From: William Simcock
Sent: 17 March 2026 12:26
To: Alan Smith
Subject: Re - 2025/90548, 78 John William St

LOWER GROUND FLOOR

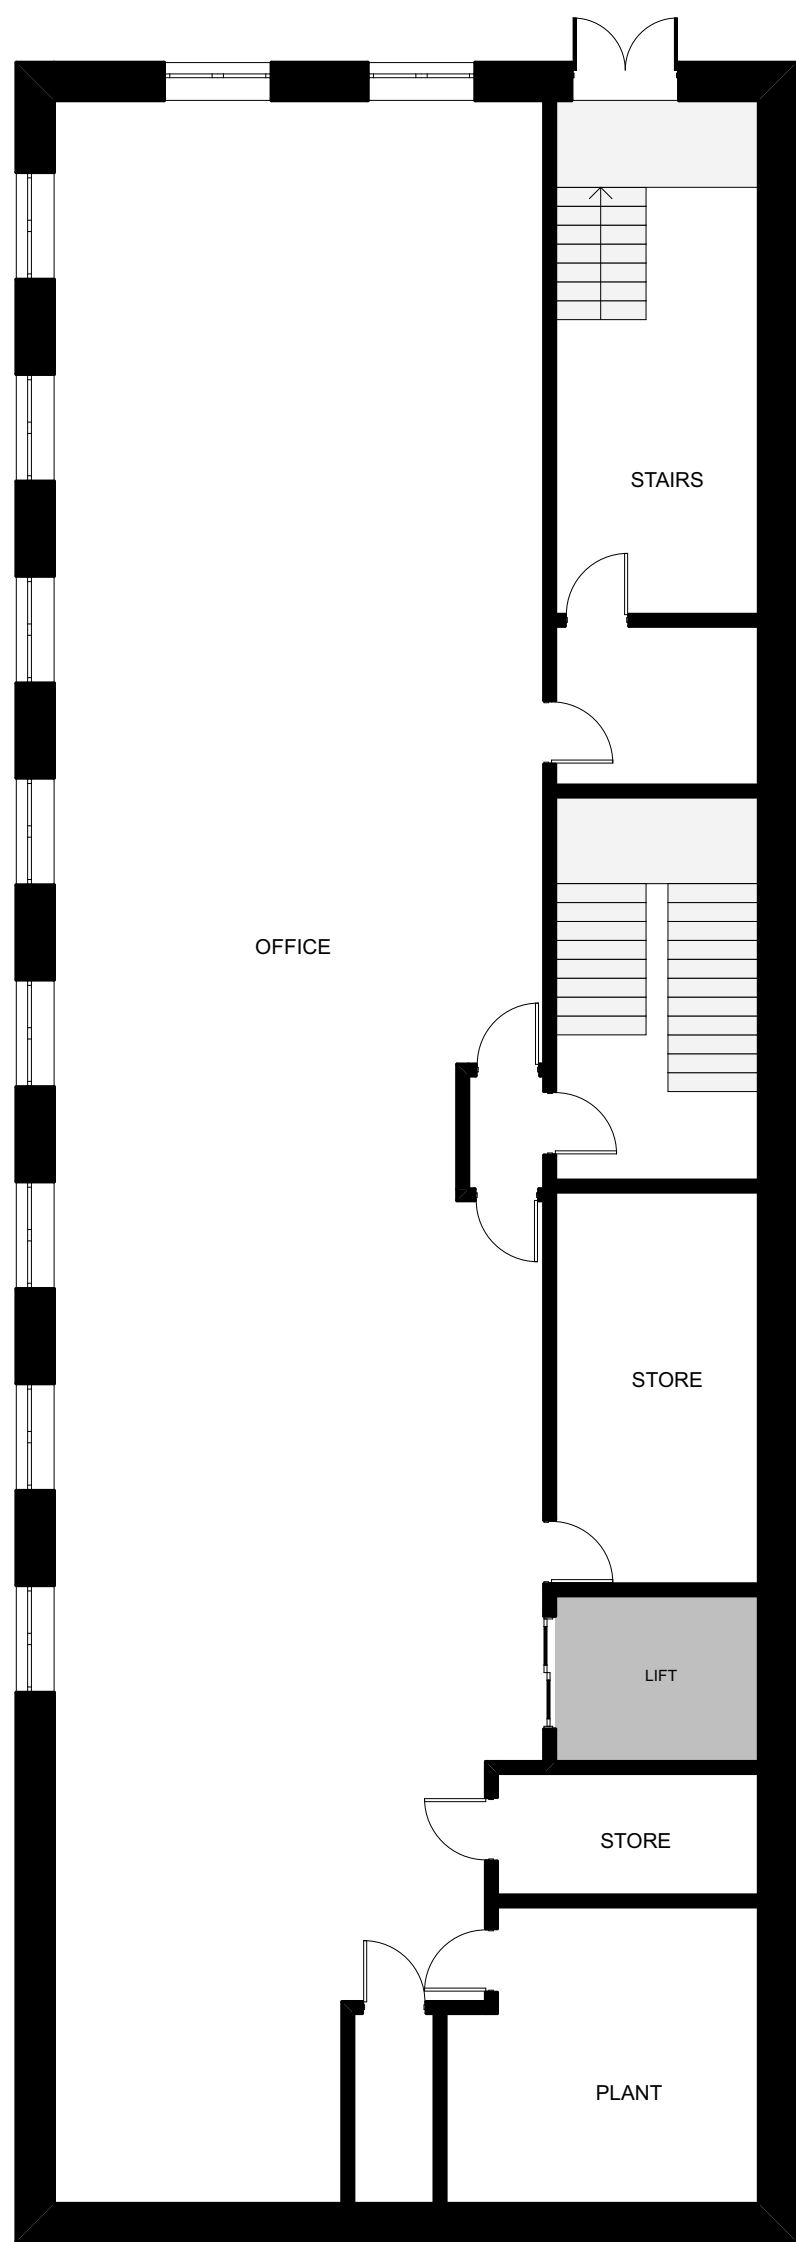
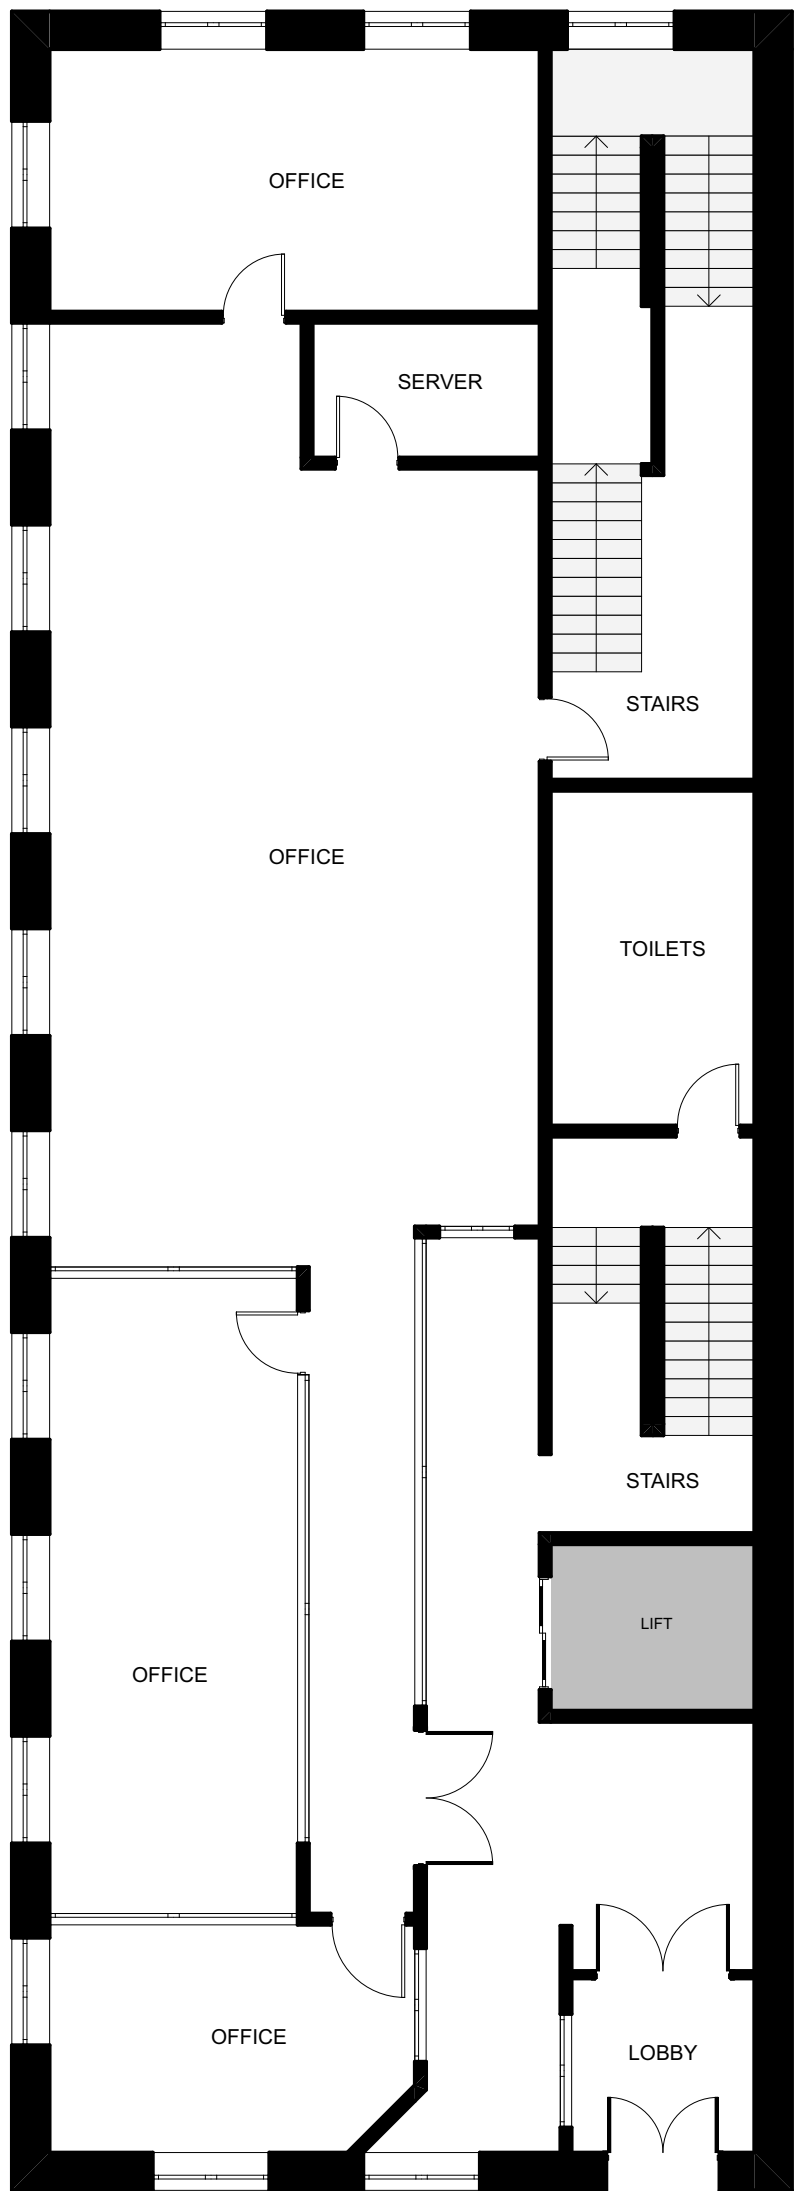
In your consultation response of July 2025, you calculated that total waste capacity required would be 2,520 litres and I will accept this on the basis that:

- i. The apartments (all but one) are single bedroom so it is unlikely that demand will exceed the calculated figure.
- ii. In the basement waste storage area, there isn't room for another Eurobin but they could without difficulty fit.

for each type of waste. They have indicated space for four no. Eurobins, so 2,200 litres for each type of waste, which

falls short by 13%. I am minded to

I'm happy that the amount of waste produced will be contained in the waste containers and that any excess waste will be stored to make up the short fall of capacity. However, any extra waste above the capacity provided would have to be dealt with by the landlord.

red internally in the building. My concern is that any excess waste will be placed out for collection with the bulk bins. If necessary, I would need to consult the landlord or managing agent. If the developer is clear about that then I am happy to agree to your proposal.
